WEST SUSSEX COUNTY COUNCIL CONSULTATION

TO:	Arun District Council FAO: Michael Eastham
FROM:	Stephen Gee WSCC - Highways Authority
DATE:	3 October 2019
LOCATION:	Land off Arundel Road Angmering BN16 4ET
SUBJECT:	A/122/19/OUT Outline application with some matters reserved for the erection of up to 160 dwellings with public open space, landscaping and sustainable drainage systems (SuDs), vehicular access point from Arundel Road together with up to 557 square metres of B1/B2 units with associated parking provision & vehicular access point from Arundel Road & land made available for expansion of current sports pitch provision to form a sports-hub (following the demolition of existing commercial units and one bungalow) (resubmission following A/36/18//OUT). This application is a Departure from the Development Plan.
DATE OF SITE VISIT:	
RECOMMENDATION:	Objection / More Information
S106 CONTRIBUTION TOTAL:	TBA

| DRAWING NUMBER:<br><b>2020-F01</b> | REVISION:<br><b>-</b> |

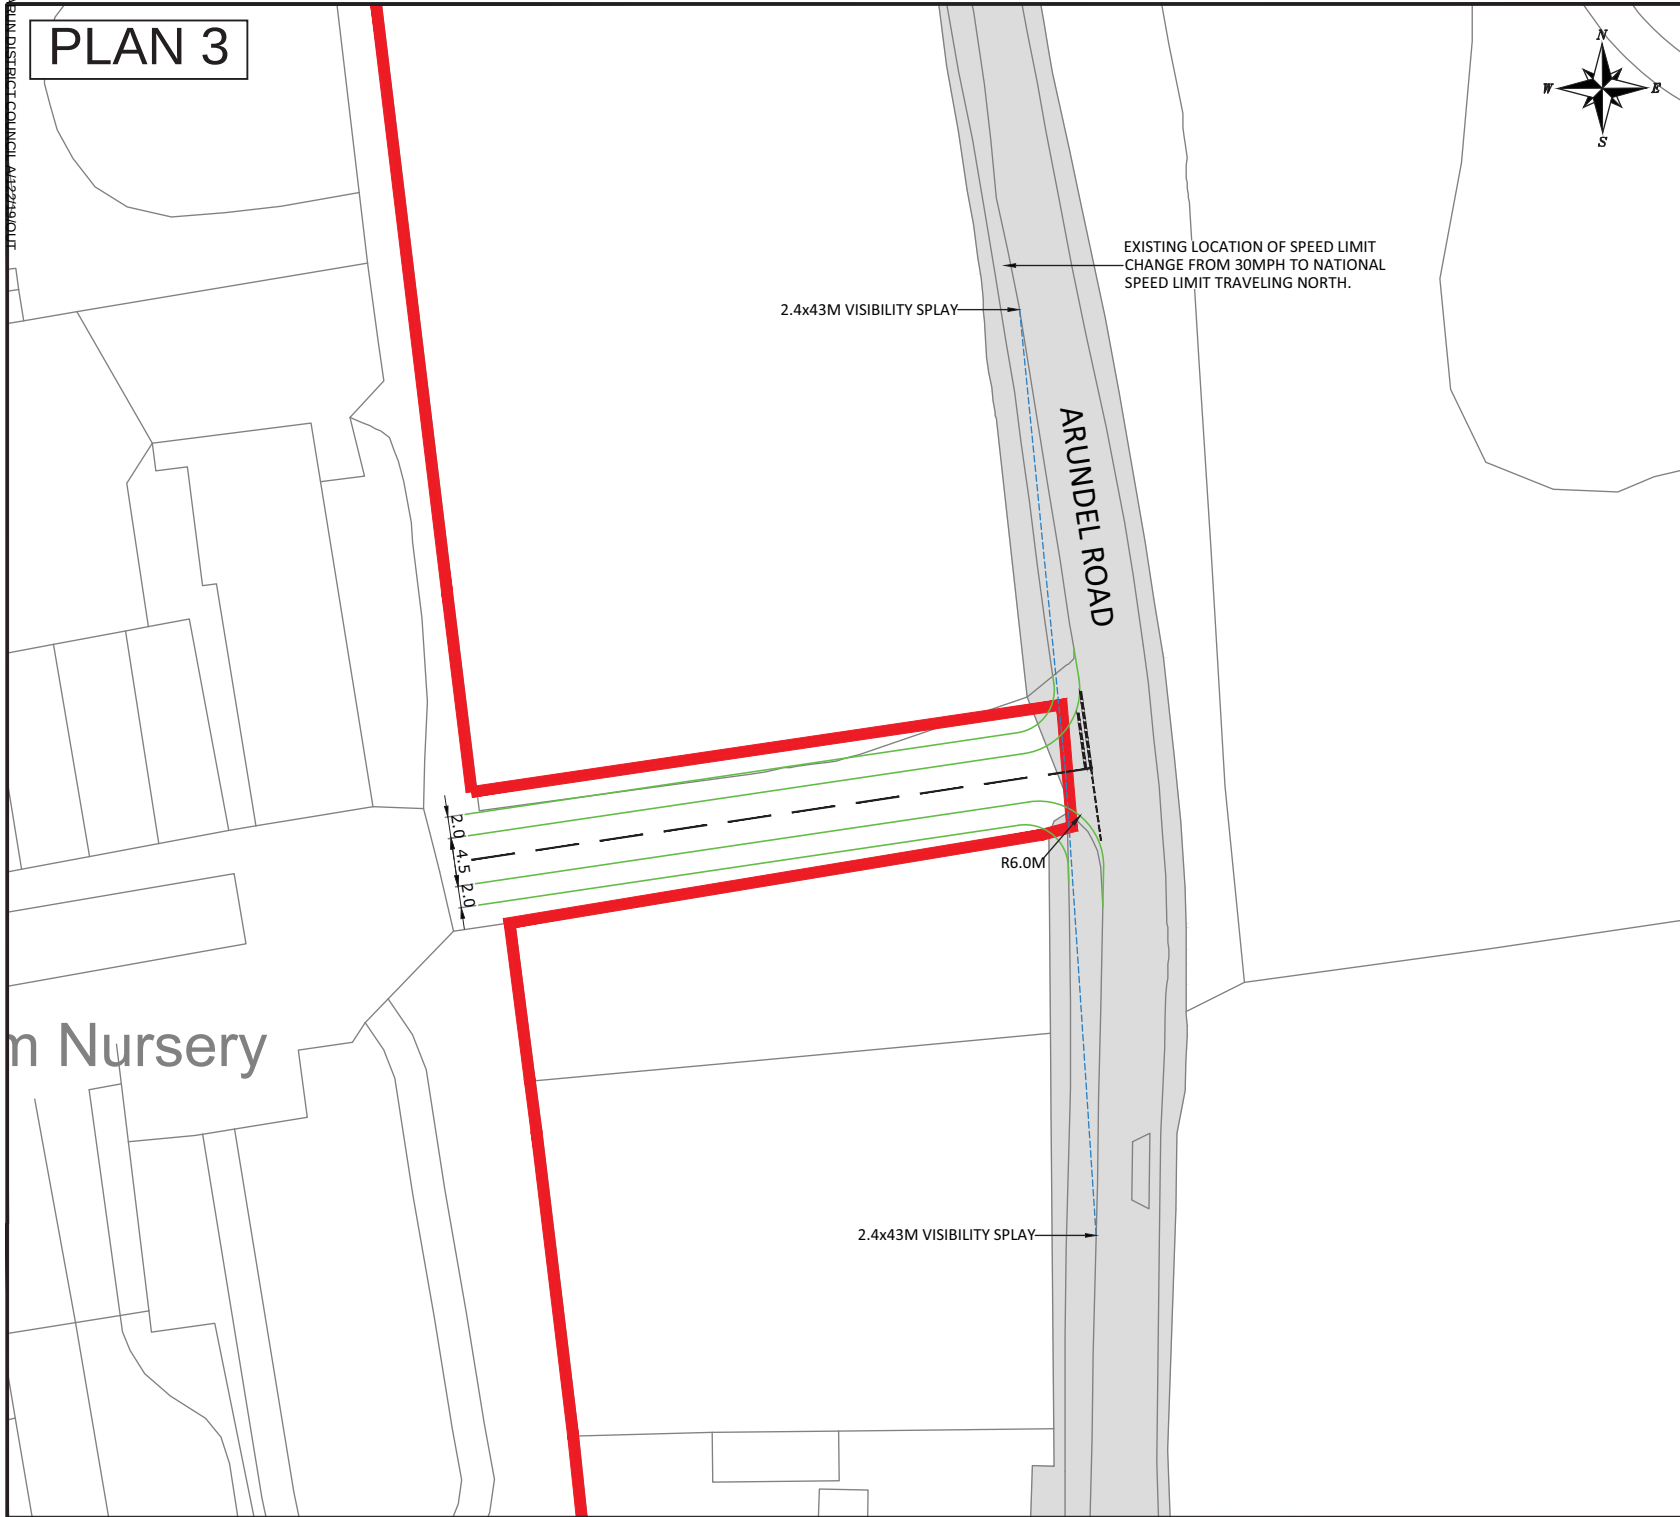
From the drawing ref 2020-F01 it is apparent the visibility splays to the south (where northbound vehicles record a higher 85th% speed) could be provided in excess of 59m and MfS requirements if vertical alignment allows. The applicant should clarify if any additional length can be provided.

Consideration should also be provided to widening the running lanes.

- Confirmation of maximum achievable visibility splay at Northern access to the south;
- Consideration of widening the running lanes along Arundel Road in the vicinity of the site access;
- Exception report or designers response incorporating F4 of GG119;
- Stage 1 Road Safety Audit to be provided on the proposed signalised pedestrian crossing of Arundel Road.
